Lower Thames Crossing

5.4.1.6 Draft Agreed Statement of Common Ground between (1) National Highways and (2) Natural England (Clean version)

**DATE: October 2023
DEADLINE: 5**

Planning Inspectorate Scheme Ref: TR010032
Application Document Ref: TR010032/APP/5.4.1.6

*Local Landscape Character Area boundaries of the Kent Downs AONB LCA, West Kent Downs, Sub-areas Cobham and Shorne*

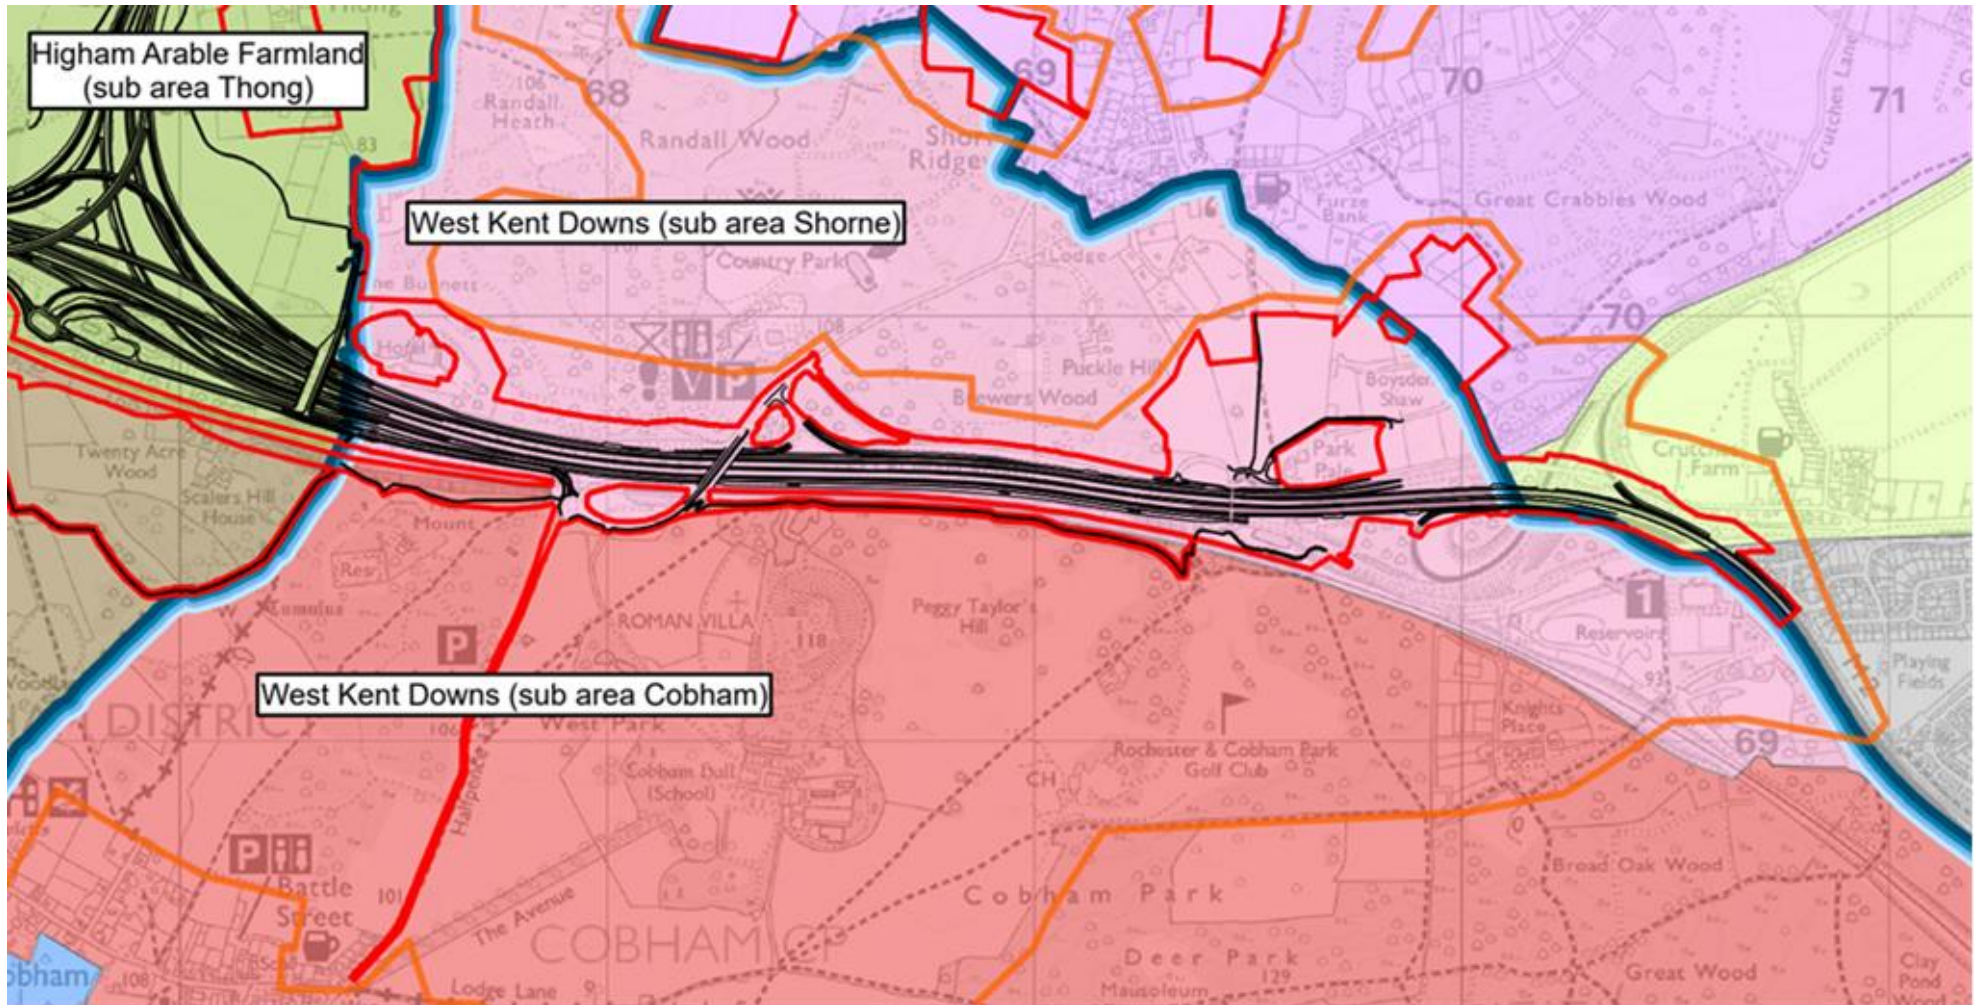
Topic	Item No.	Natural England Comment	The Applicant's Response	Application Document Reference	Status
			details are provided in ES Chapter 8: Terrestrial Biodiversity.	Representation paragraphs 10.1.1 – 10.1.4 [REP1-262]	
Landscape and visual					
Visual					
Baseline	2.1.105 WR (DL5)	The Environmental Statement appears to show incorrect boundaries for the contiguous West Kent Downs (sub area Cobham) and West Kent Downs (sub area Shorne) Local Landscape Character Areas (LLCA). The Cobham sub area boundary largely follows the northern boundary of the existing A2/High Speed 1 Rail Line alignment whereas the Environmental Statement shows the same Character Area boundary running to the south of the A2/High Speed 1 Rail Line. The incorrect transposition of the boundaries for these two Character Areas is likely to mean that the assessment of landscape and visual effects within the Environmental Statement are incorrect.	The boundaries of the LLCAs within the Kent Downs AONB have not been incorrectly transposed. As detailed in Appendix A of Comments on Written Representations, the boundaries of character areas identified in the studies have been used to inform the definition of the LLCAs, which have been used as a basis for the assessment of effects on the landscape at the local level. In a limited number of locations, the boundaries of the published character areas have been slightly adjusted through detailed study and analysis undertaken for the LVIA. Notwithstanding this slight difference in the West Kent Downs (sub area Cobham) LLCA boundary, the effects of the Project are fully assessed either as direct or indirect effects within the West Kent Downs (sub area Cobham) LLCA	ES Chapter 7: Landscape and Visual [APP-145] Comments on Written Representations Appendix A- Statutory Environmental Bodies [REP2-046] Natural England's Written Representation paragraphs 6.1.3, 6.1.4 and 6.1.7 [REP1-262]	Matter Under Discussion

Topic	Item No.	Natural England Comment	The Applicant's Response	Application Document Reference	Status
			and/or the neighbouring West Kent Downs (sub area Shorne) LLCA. The findings of these two assessments are then brought together into a combined assessment for the overarching West Kent Downs Landscape Character Area (LCA) 1A. The combined effects reported in the landscape impact summary Tables 7.33 and 7.34 in Section 7.9 of ES Chapter 7: Landscape and Visual, and the overall conclusion of the landscape and visual impact assessment would therefore not differ if the Cobham and Shorne sub area boundary is drawn in a different location.		
Methodology	2.1.24	The viewpoint and photomontage locations and methodology have been agreed with Natural England.	Methodology agreed.	ES Chapter 7: Landscape and Visual [APP-145] Natural England's Written Representation paragraph 6.1.5 [REP1-262]	Matter Agreed
